**re: Geotechnical Review of Grading Plan & Site Servicing
Proposed Multi-Storey Building
384 Arlington Avenue – Ottawa, Ontario**
**to: Windmill Developments – Kristen Jorgensen –
Kristen.jorgensen@windmilldevelopments.com**
date: October 7, 2024
file: PG6263-MEMO.03

Further to your request and authorization, Paterson Group (Paterson) prepared the current memorandum to document our review of the grading and servicing plans for the proposed multi-storey building to be located at the aforementioned site. This memorandum should be read in conjunction with Paterson Group Report PG6263-1 Revision 1 dated October 7, 2024.

SERVICING PLAN

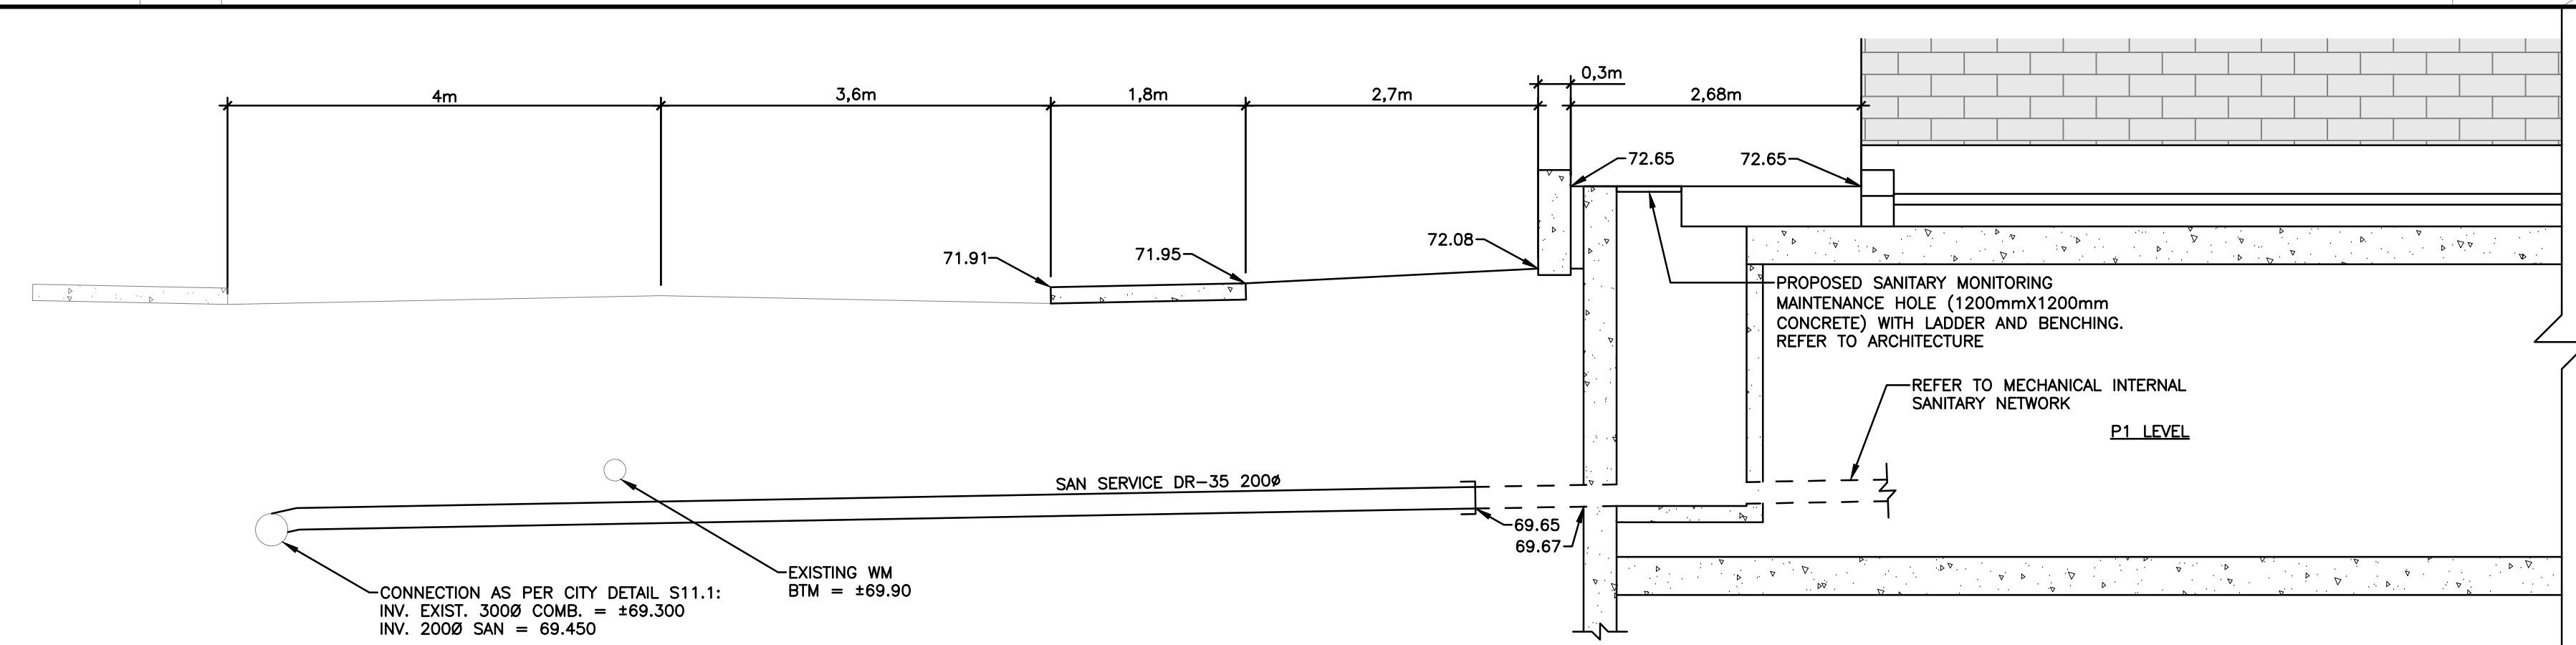
- Project No. 12805 – Drawing No. C004 – REV 1 – Servicing Plan – dated October 4, 2024.

Based on our review of the site servicing plan, sufficient soil cover has been provided to the proposed watermain, sanitary services and the primary stormwater services. However, the emergency stormwater overflow services were noted to be provided with insufficient soil cover. Reference should be made to Figure 1 – Site Servicing Plan Review, attached.

Where insufficient soil cover (i.e. less than 2.1 m of soil cover is present above the obvert of the pipe) is available, the following frost protection criteria should be followed:

Table 1 – Rigid Insulation Recommendations for Storm Sewer Pipes with Reduced Soil Cover			
Thermal Condition	Soil Cover Provided (mm)	Insulation Dimensions	
		Thickness (mm)	Extension (mm)
Unheated	600 to 900	125	Extend 1200 mm horizontally beyond edge face of the pipe
	900 to 1200	100	Extend 1200 mm horizontally beyond edge face of the pipe
	1200 to 1500	75	Extend 900 mm horizontally beyond edge face of the pipe
	1500 to 1800	50	Extend 600 mm horizontally beyond edge face of the pipe
	1800 to <2100	25	Extend 300 mm horizontally beyond edge face of the pipe

All rigid insulation should consist of either Dow Chemical High-Load 40 (HI-40), Styro Rail SR.P400, or equivalent approved by Paterson. The placement of all insulation within the service trenches must be reviewed and approved by Paterson personnel at the time of construction
